# KITTITAS COUNTY

## DEPARTMENT OF PUBLIC WORKS

**TO:** All Staff  
**FROM:** Public Works Plan Review Team  
**DATE:** September 19, 2022  
**SUBJECT:** VA-22-00004 Pemsel

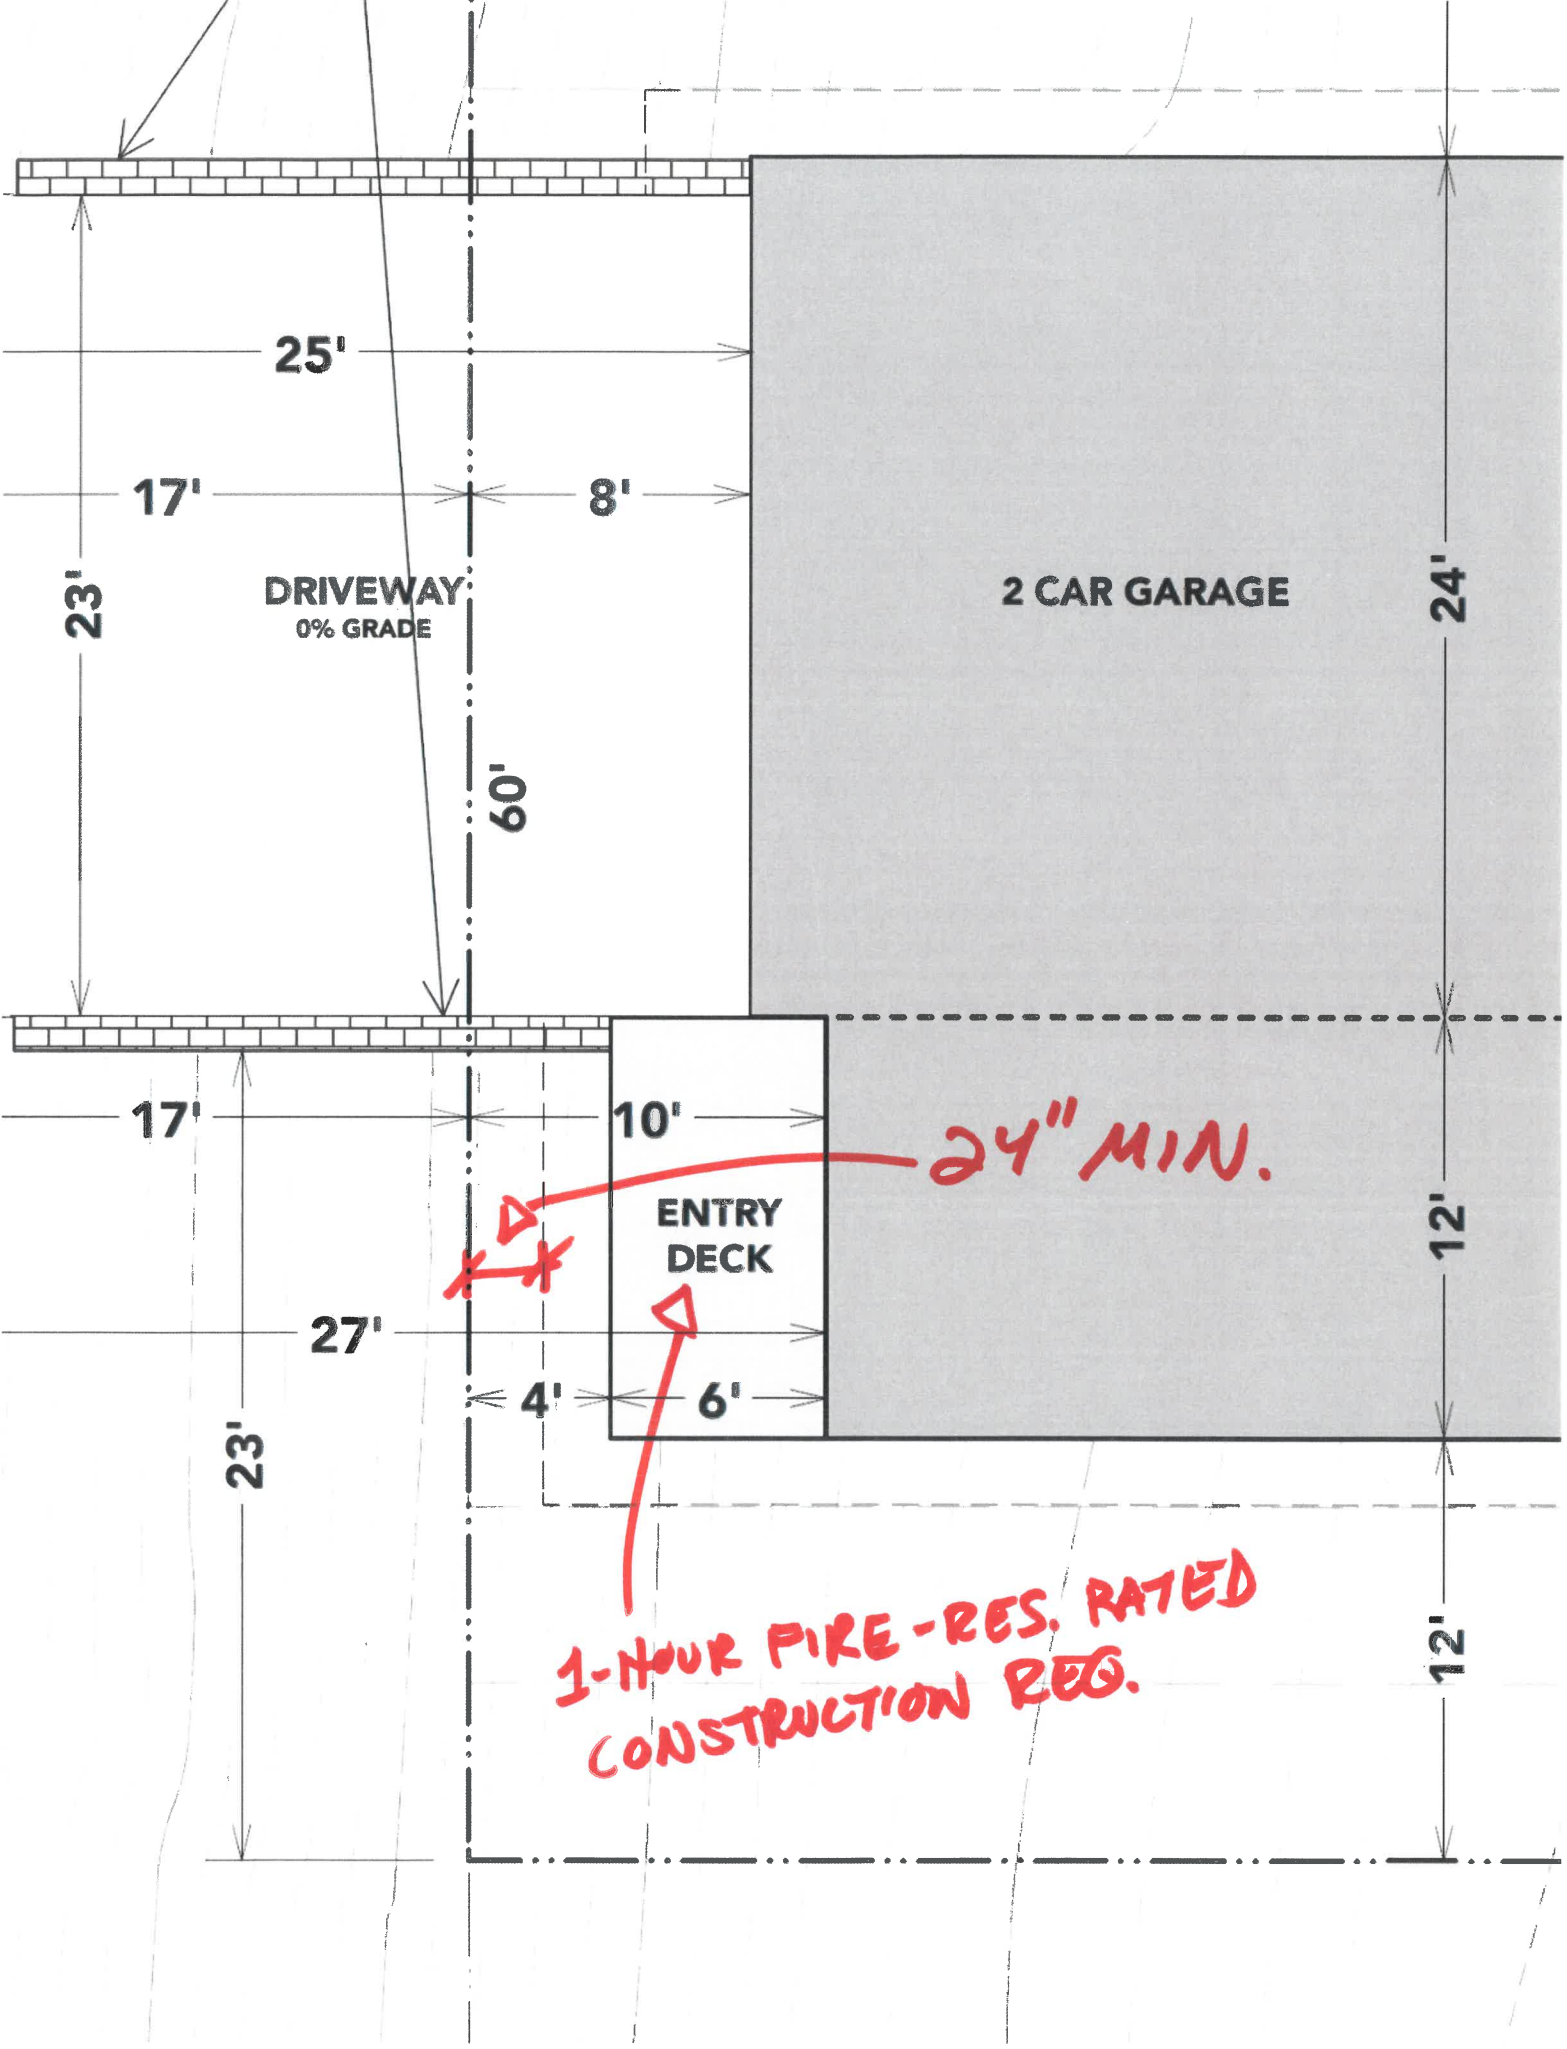
<b>ACCESS</b>	1. No Access Comments (TM)
<b>ENGINEERING (CC)</b>	<ol style="list-style-type: none"><li>1. Unusual hazardous slopes in the area will require any grading performed on site be done under an Engineered Grading Permit. Please contact Public Works for instructions on how to procure this permit.</li><li>2. It may be the case that Public Works requires additional mitigation within the Clear Zone (10ft from edge of pavement). Public Works may impose some limitations on the type of retaining wall used within the Right of Way, such as preventing the use of “pour in place” or “precast” structures.</li><li>3. Be aware that Maintenance of Hyak during winter months may require snow be blown towards the edge of the county Right of Way. Public Works recommends limiting the setback variance to 10 feet from the front property line.</li></ol>
<b>SURVEY</b>	<b>No survey comments (JT)</b>
<b>FLOOD &amp; WATER MITIGATION/ METERING</b>	No comments (SC)
